From: Rael, Rudy E.
Sent: Tuesday, November 01, 2016 9:11 AM
To: 'David Soule (david@riograndeengineering.com)'
Cc: Carrillo, Abiel X.
Subject: 6420 Petirrojo NW

Based upon the information provided in your submittal received 10/26/16, the above referenced Grading and Drainage plan dated 10/26/16 cannot be approved for Grading Permit or Building Permit until the following comments are addressed:

ENGINEER'S SEAL	LOT 4, BLOCK 10, UNIT 22 VOLCANO CLIFFS SUBDIVISION	DRAWN BY JDG
	GRADING AND DRAINAGE PLAN	DATE 10-26-2016
		SHEET # 1 OF 1
10/26/16	DAVID SOULE P.E. #14522	JOB #

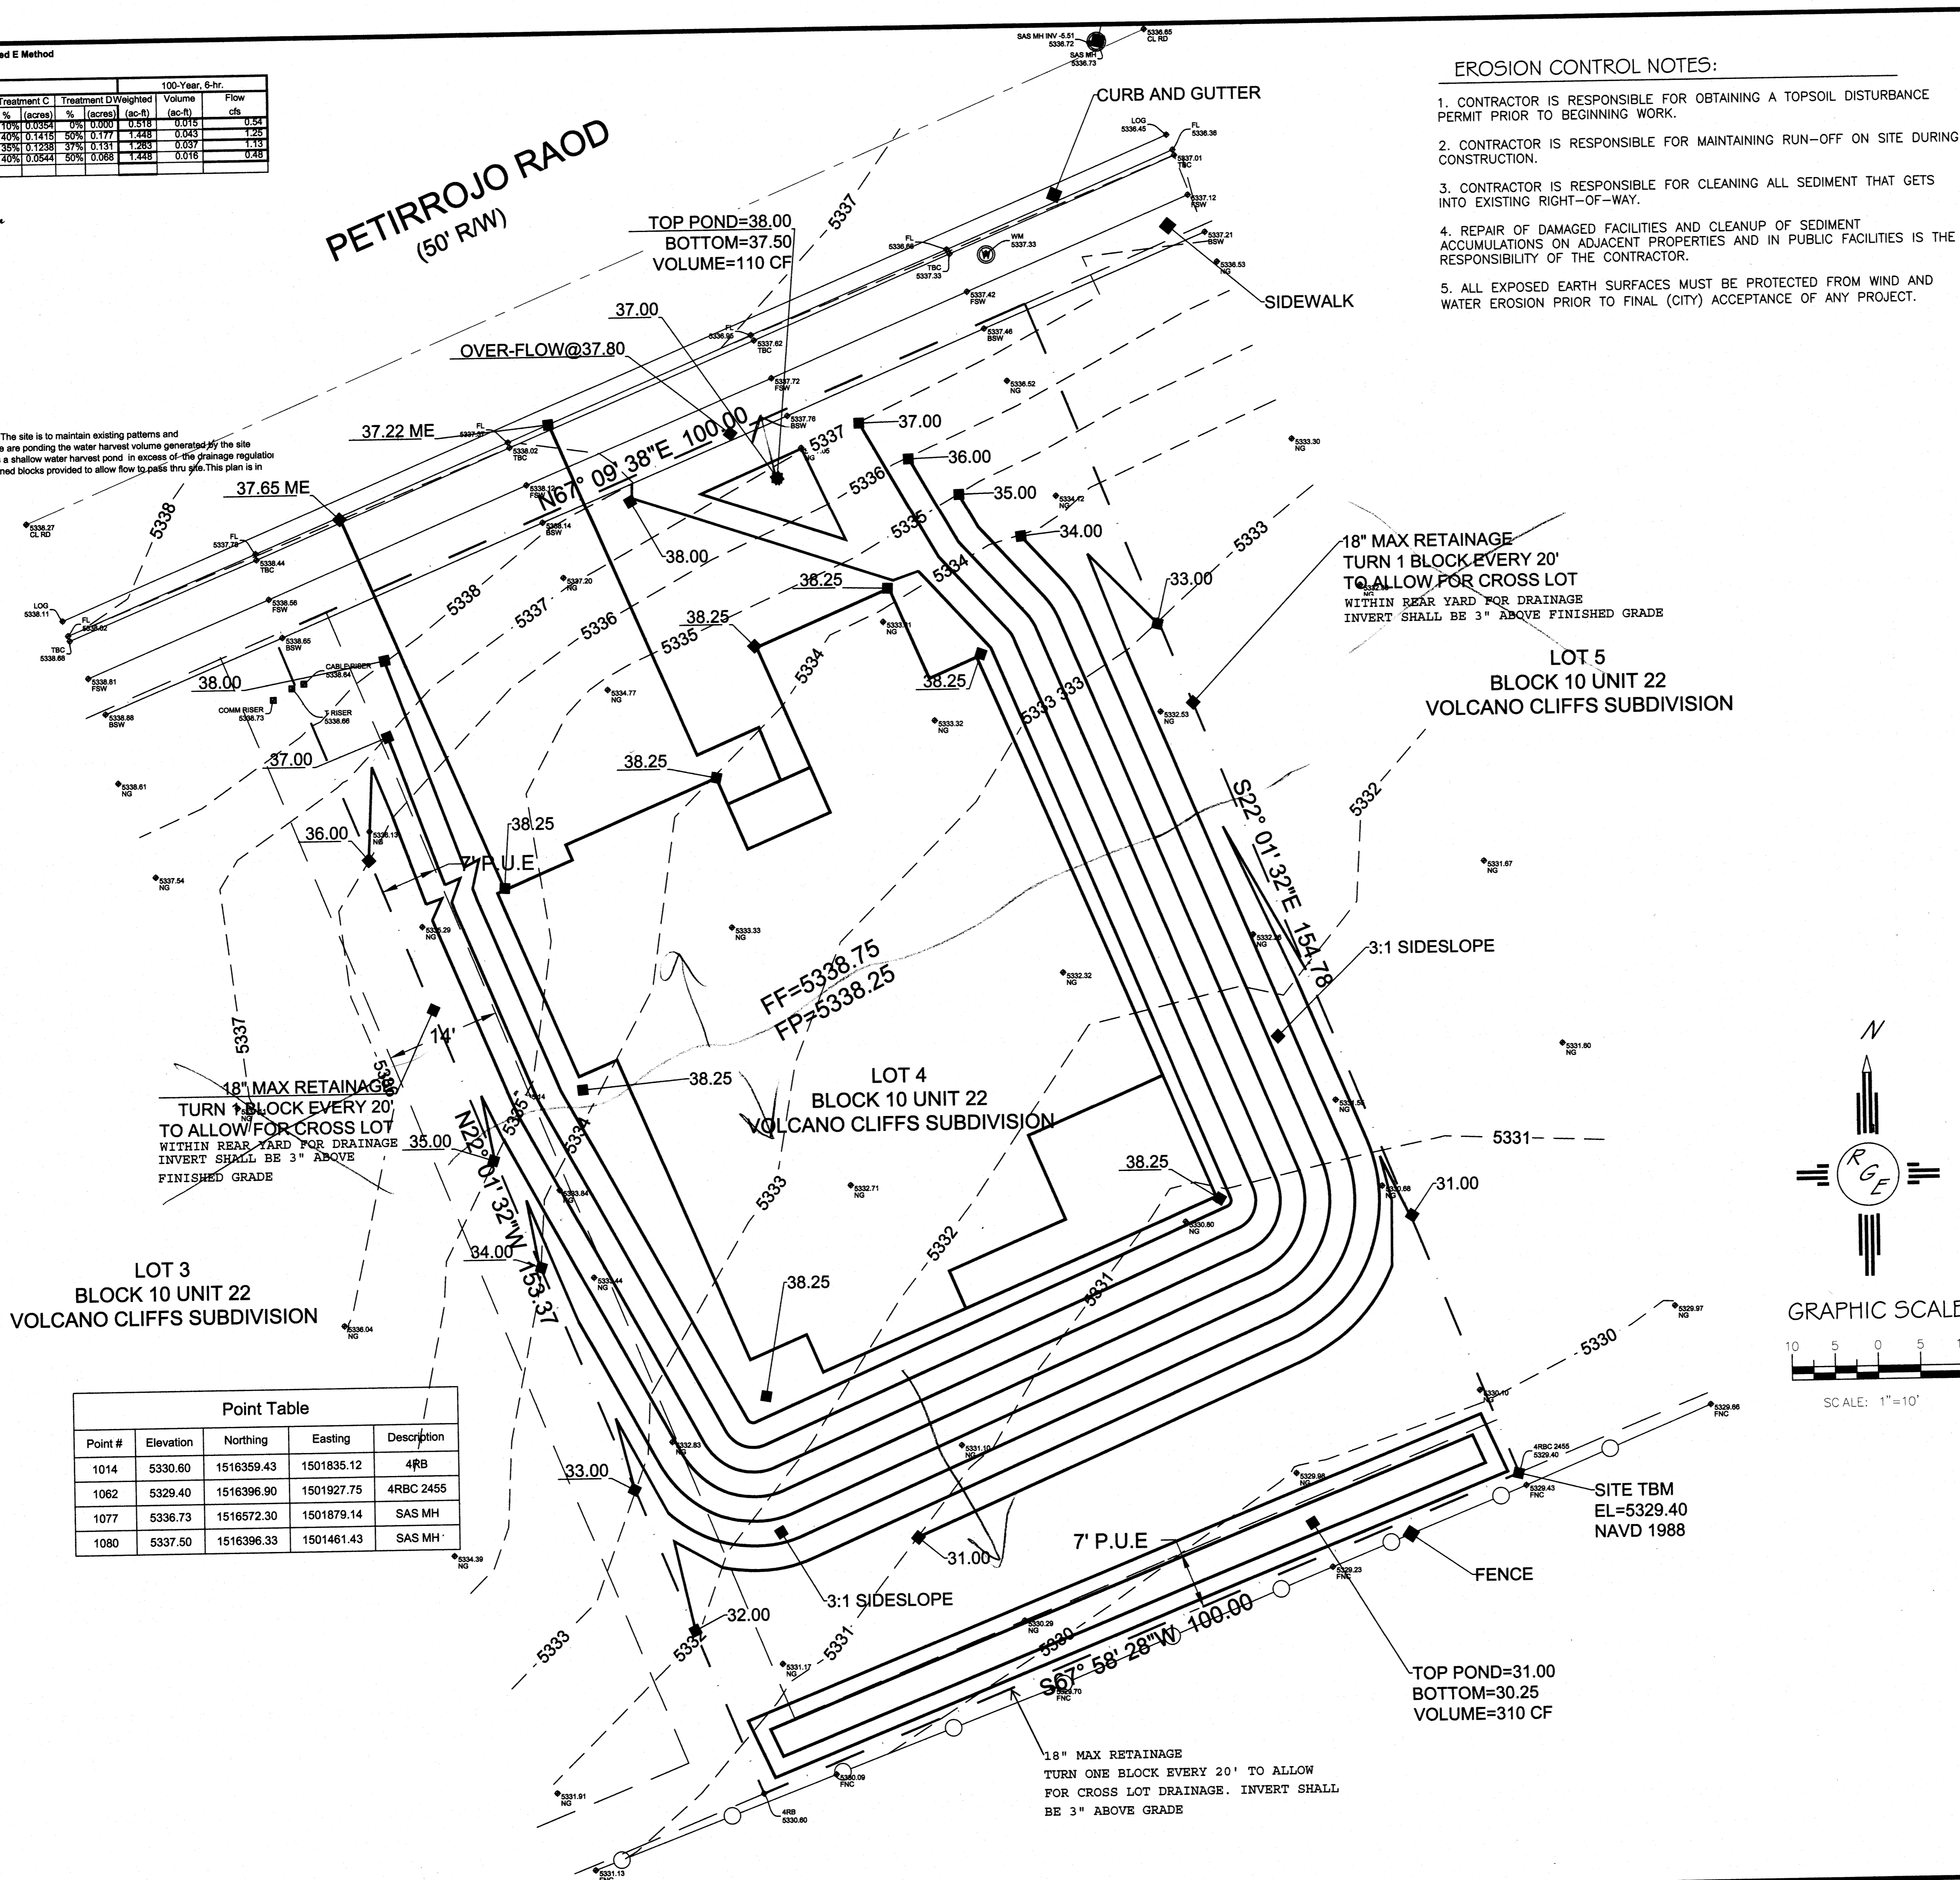
- Enlarge the drainage calcs or provide on a separate sheet with the proper font size. Once submitted the calculations will be checked.
- Remove the statement, turn block every 20'.... This lot drains half toward the front and half toward the rear, going through a water Quality pond first.
- Provide a note stating the requirement that a separate wall permit must be provided when the fence is being built, at time of Building permit or later. This plan needs to accompany the wall permit set, otherwise will not be approved.
- Provide a statement for the requirement of a pad certification before the concrete slab is poured or before rough in occurs.
